**DRB CASE NO/PROJECT NO: 1004986**

Project Name: FOUR HILLS VILLAGE INSTALLMENT 11-A

**January 30, 2008  
DRB Comments**

**RE: Tract 2, Four Hills Village**

**PLAT OF  
LOTS 2-A and 2-B  
TRACT 2  
FOUR HILLS VILLAGE  
INSTALLMENT 11-A**

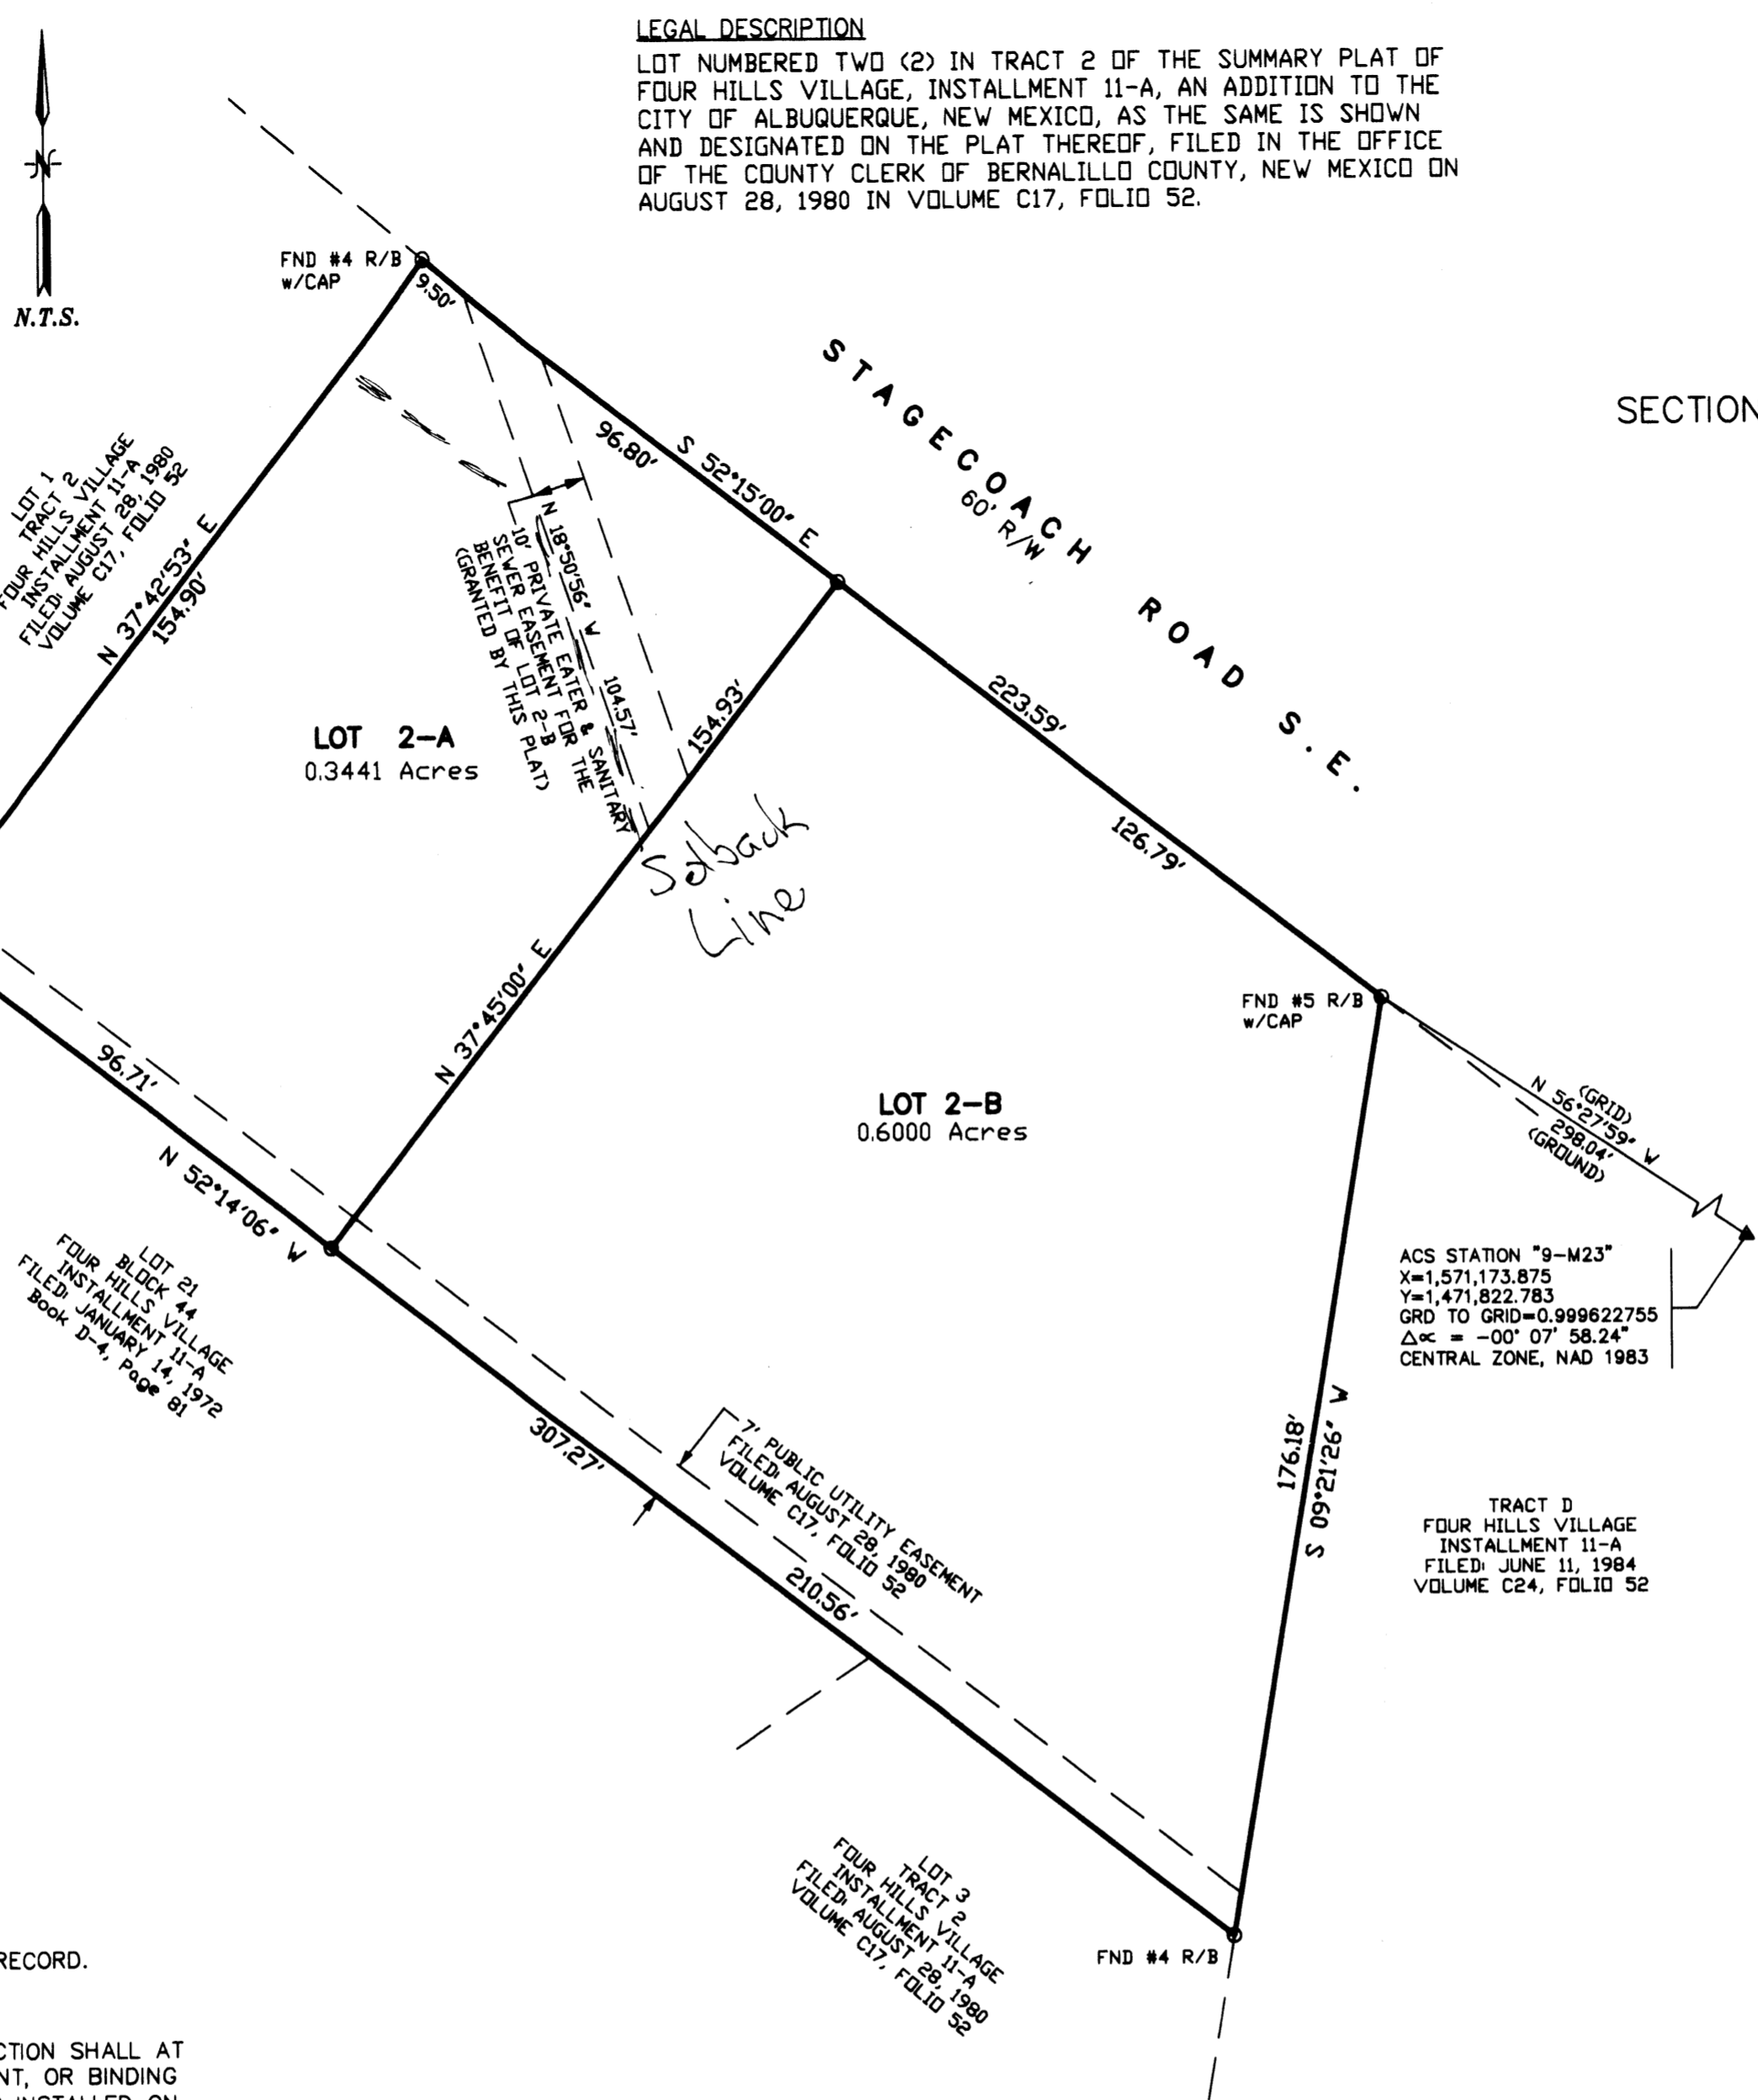
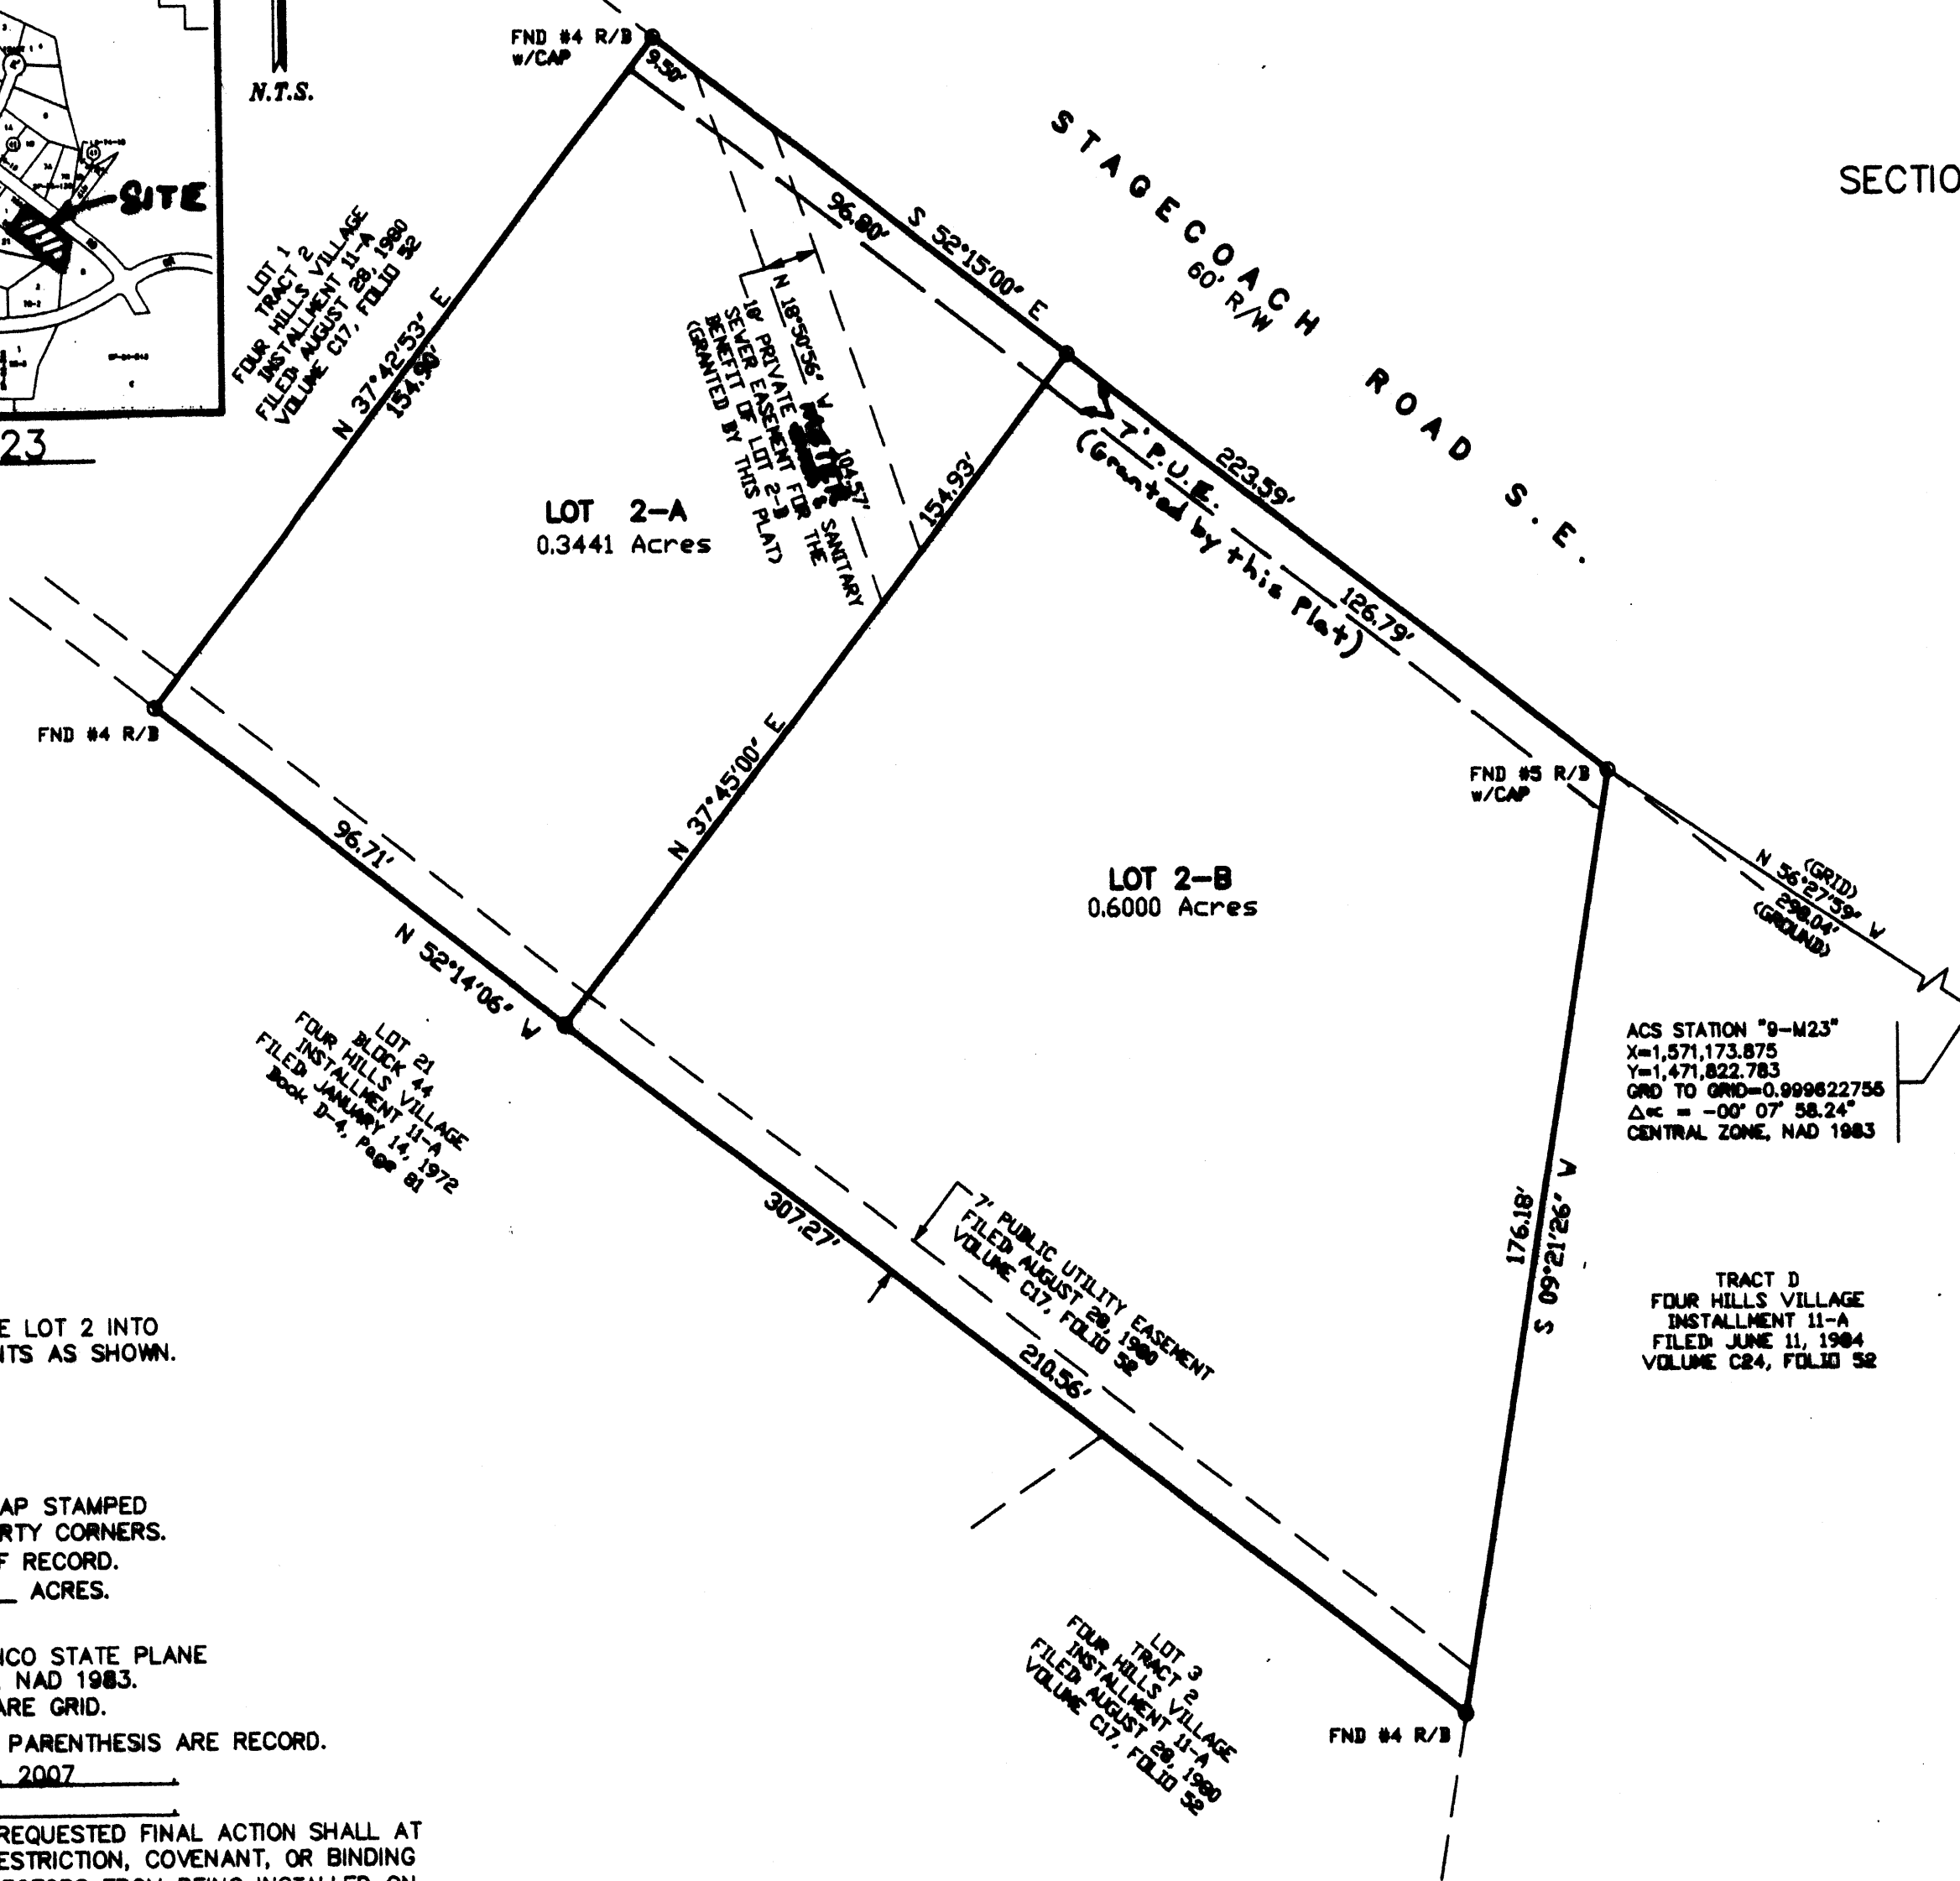
For future reference, please revise solar note (No. 10) to be specific to this type of request, i.e. replace the words "REQUESTED FINAL ACTION" with the words "THIS PLAT" at the beginning of the note, and also replace the words "PROPOSED PLAT" at the end of the note with the words "THIS PLAT."
